16 July 2021

SSD 11233241 – PROPOSED PRIMARY SCHOOL, LOT 302 DP1228766, FAIRLEY STREET, MURRUMBATEMAN.

I refer to your correspondence regarding the subject Application which was referred to Transport for NSW (TfNSW), for assessment and comment.

Figure 3-8 Fencing strategy
Source: Pedavoli Architects

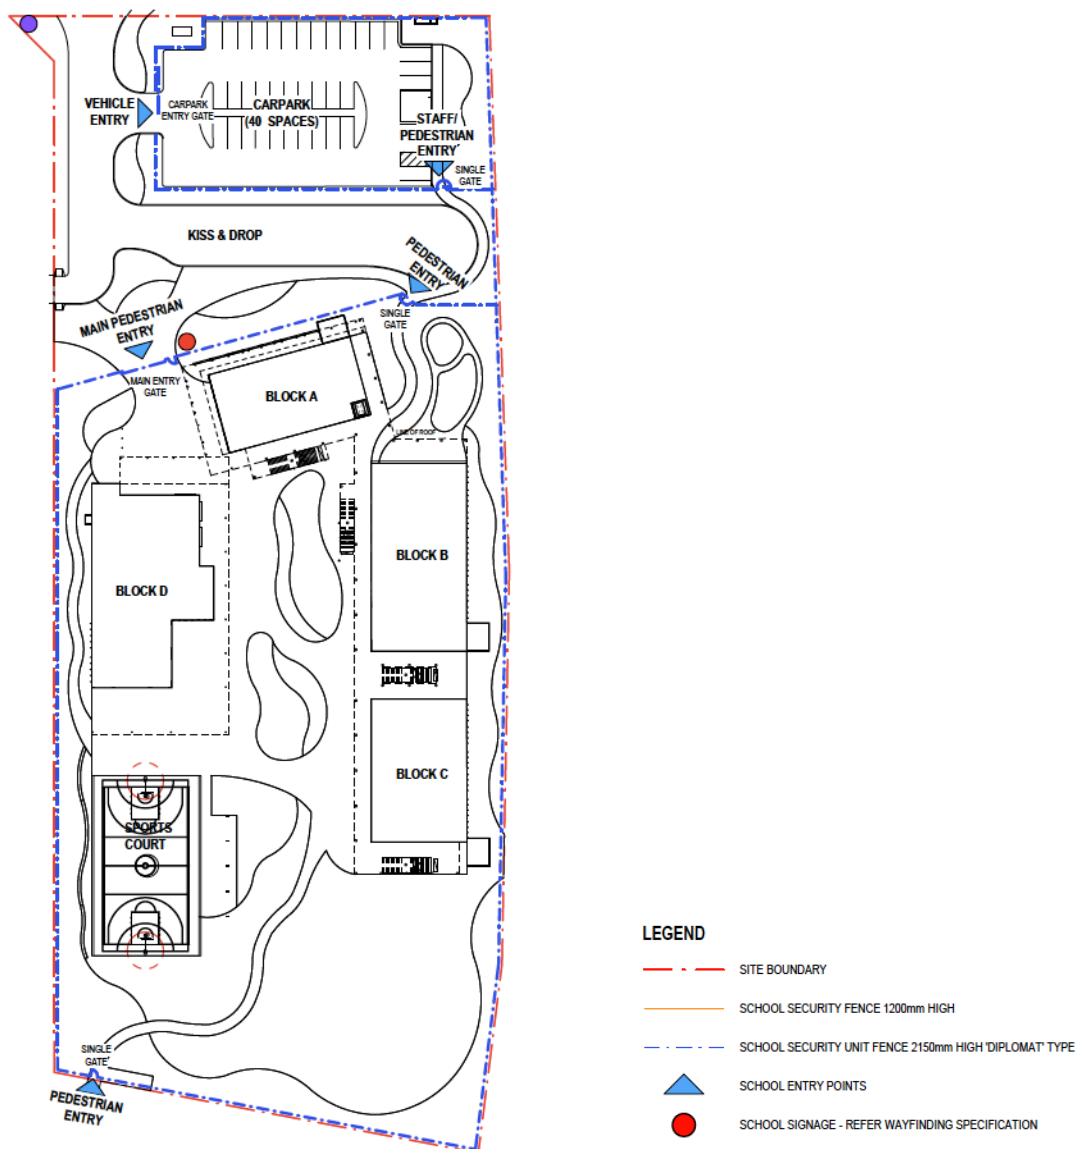
- Fencing is to be located around the school grounds with gateways to defined access arrangements for pedestrians to the school grounds and deny access from the road reserve of the Barton Highway;

Figure 3-9 Vehicular access

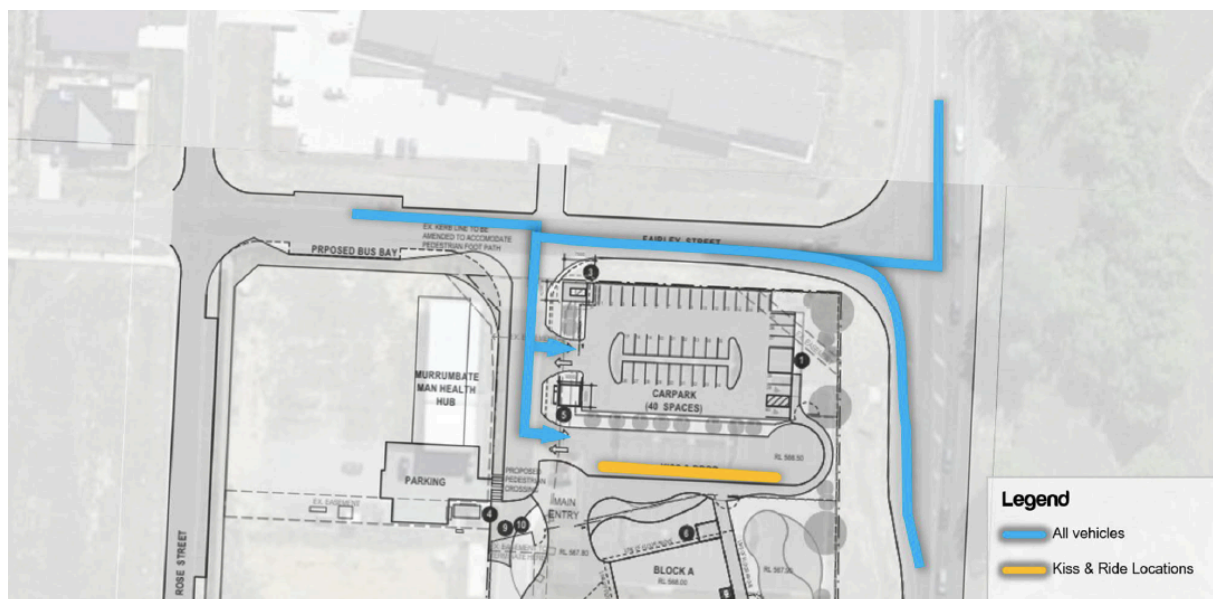
- The development is to provide for 40 car parking spaces and kiss and drop facilities on site. Consideration should be given to the use of this kiss and drop area for buses to utilise for school excursions outside of the peak times for the kiss and drop facility;

- Operation of the kiss and ride facility relies on a turnover of a maximum of 2 minutes per vehicle. Operational measures are required to be implemented to ensure this turnover for the lifetime of the school;

Figure 3-11 Signage location plan
Source: Pedavoli Architects

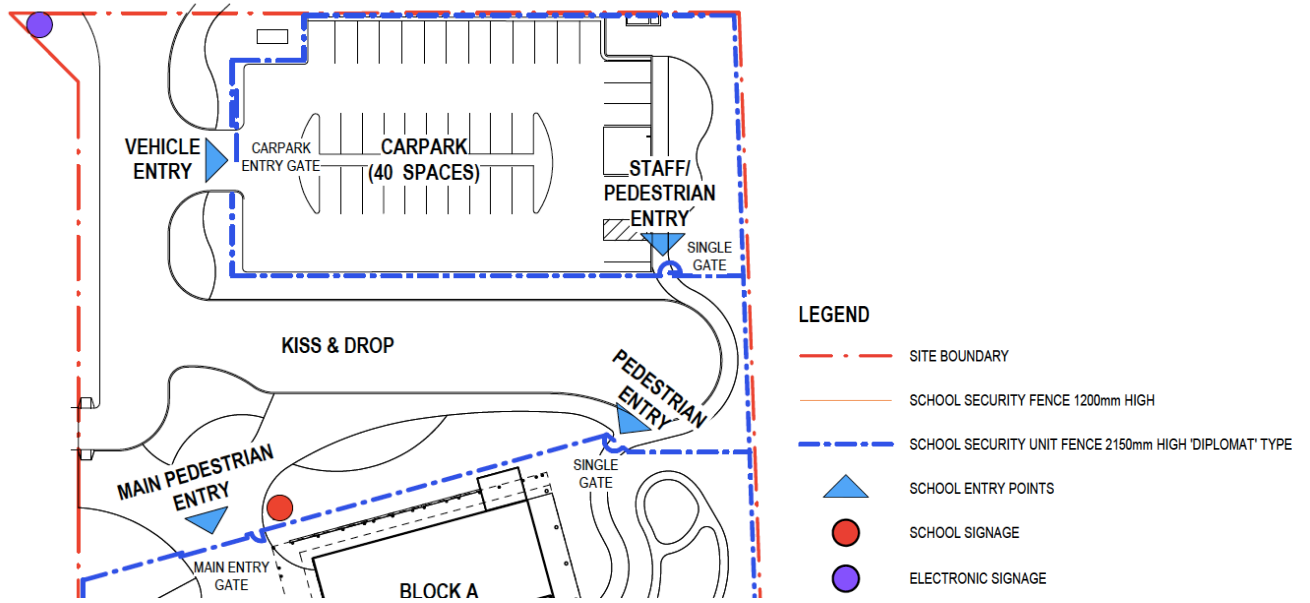
- Digital signage is to be located and oriented to Fairley Street. No signage is proposed to be orientated towards the Barton Highway;
- a proposed bypass of Murrumbateman has been proposed for the future with the preferred corridor for the bypass being located to the east and remote from the proposed school site. The proposed timing for the construction of the bypass is not finalised at this stage.
